from
**Southern
Water**

Our ref
PLAN-035241

Proposal: Erection of 75 No. dwellings with associated parking, public open space & the creation of a new vehicular access. This application affects the character & appearance of the Main Road/Church Road Conservation Area & affects the setting of listed buildings.

Site: Y/98/20/PL: - Bonhams Field, Main Road, Yapton, BN18 0DX.

TITLE Proposed Drainage Strategy Plan			
SCALE	1:1000 @ A3	PROJECT No.	23018
REPORT TYPE	FRA	DRG. No.	7 A

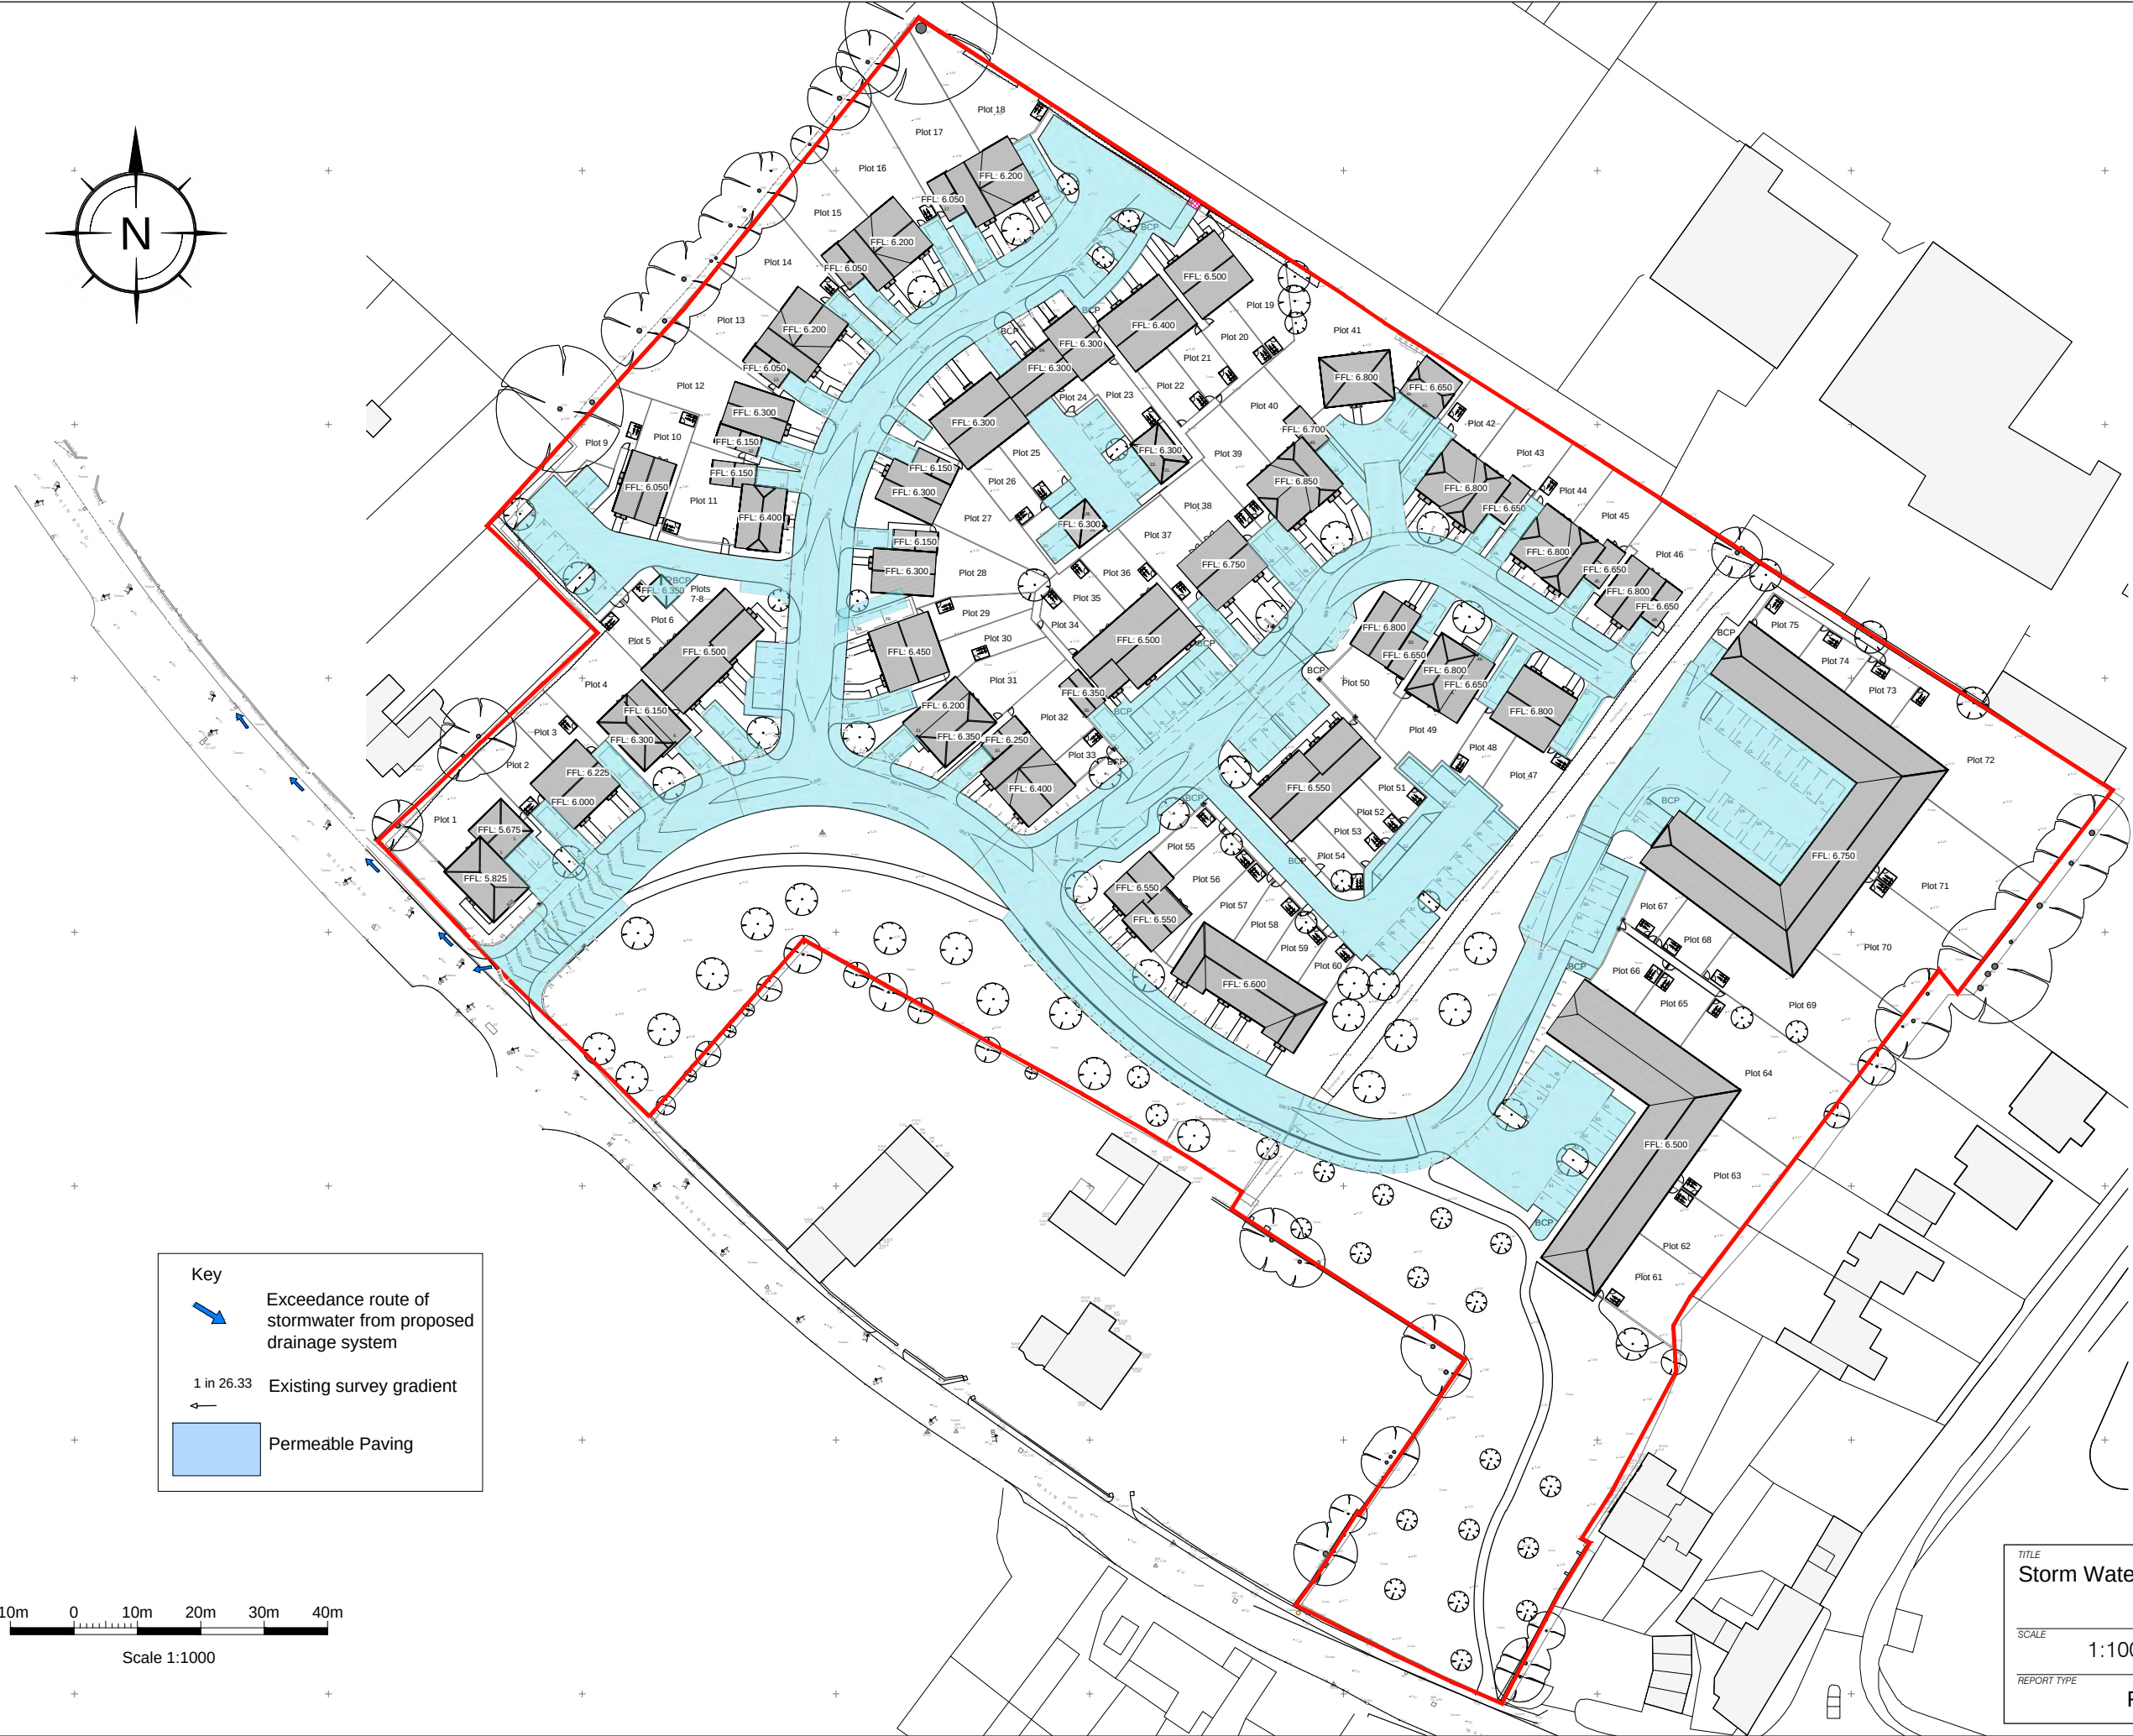
The supporting documents make reference to drainage using Sustainable Drainage Systems (SuDS).

Under certain circumstances SuDS will be adopted by Southern Water should this be requested by the developer. Where SuDS form part of a continuous sewer system, and are not an isolated end of pipe SuDS component, adoption will be considered if such systems comply with the latest Design and Construction Guidance (Appendix C) and CIRIA guidance available here:

Where SuDS rely upon facilities which are not adoptable by sewerage undertakers the applicant will need to ensure that arrangements exist for the long-term maintenance of the SuDS facilities. It is critical that the effectiveness of these systems is maintained in perpetuity. Good management will avoid flooding from the proposed surface water system, which may result in the inundation of the foul sewerage system.

Thus, where a SuDS scheme is to be implemented, the drainage details submitted to the Local Planning Authority should:

- Specify the responsibilities of each party for the implementation of the SuDS scheme.
- Specify a timetable for implementation.
- Provide a management and maintenance plan for the lifetime of the development.

No surface water should be permitted to be discharged to the foul sewerage system in order to protect properties downstream from flooding.

Please note there is a private surface water sewer within the development site.

Land uses such as general hard standing that may be subject to oil/petrol spillages should be drained by means of appropriate oil trap gullies or petrol/oil interceptors.
